WEST SUSSEX COUNTY COUNCIL CONSULTATION

TO:	Arun District Council FAO: Karl Roberts
FROM:	WSCC - Highways Authority
DATE:	2 December 2019
LOCATION:	Arundel Acre Arundel Road Angmering BN164EU
SUBJECT:	A/100/19/PL Change of use of land from agriculture for 3 No. travelling showpeople plots (Sui Generis) with associated storage barn, maintenance area, landscaping & infrastructure and creations of new access with associated visibility splays.
DATE OF SITE VISIT:	n/a
RECOMMENDATION:	Objection
S106 CONTRIBUTION TOTAL:	n/a

RPS Drawing/Figure Number	Rev
JNY10317/01a	-

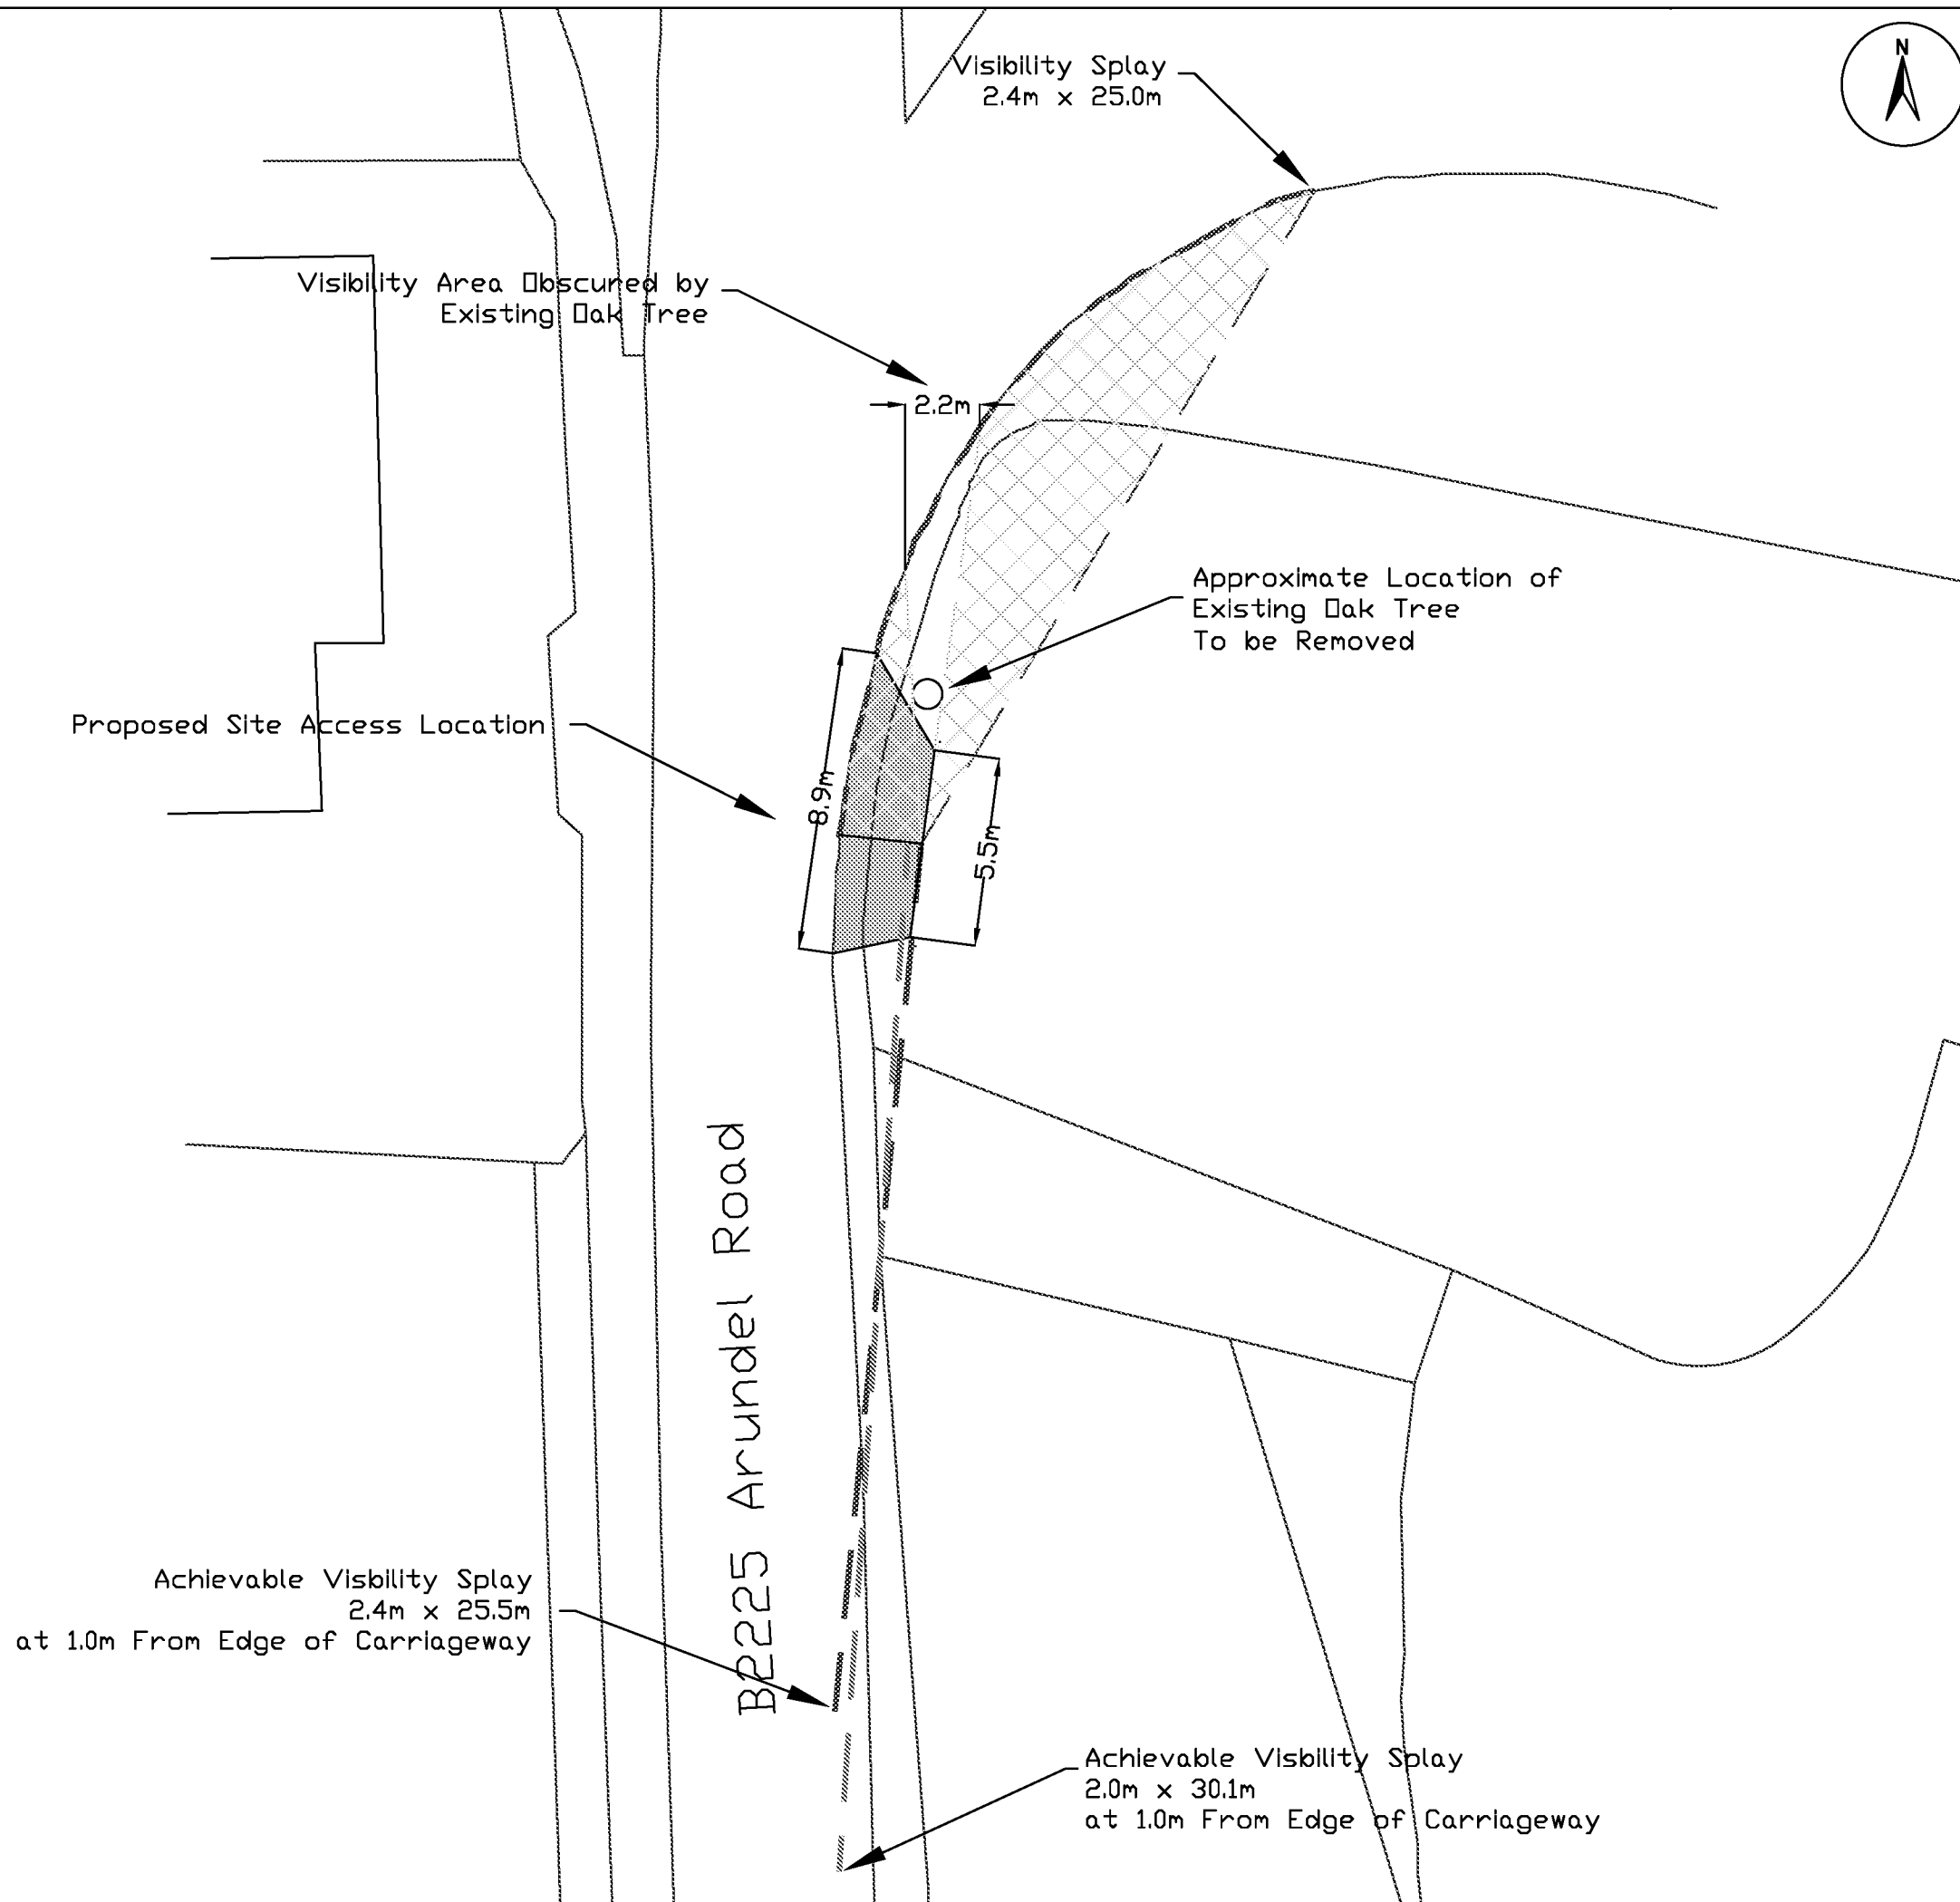
The applicants Technical Note and plan JNY10317/01a details that the access will be relocated circa 9 metres to the north.

Plan JNY10317/01a details that an existing oak tree is within this splay, it is annotated that it will be removed. The Technical Note (Paragraph 1.18) states that the oak tree will remain. This should be clarified with the applicant.

The applicants Technical Note and plan JNY10317/01a details that the access will be relocated circa 9 metres to the north.

This results in a splay of 2.4 x 25.5 metres being provided. A splay of 30.1 metres can be achieved if a 2.0 metre 'X' distance is used. This is an improvement over and the existing situation; however it does seem that these splays require the use of 3rd part land.

It should be noted that the proposal will still promote trips from slower moving larger vehicles. The demonstrated splays are significantly short of what would be expected given the approaching road speeds.

While some improvements have been demonstrated the LHA is concerned that the proposed southern splay crosses 3rd party land and therefore could not be secured in perpetuity. Even if the splay is contained wholly within land under control of the applicant or that considered highway it is still 24.5 metres short of what would be required to equate to the Manual for Streets stopping sight distance for recorded approach speeds from this direction.
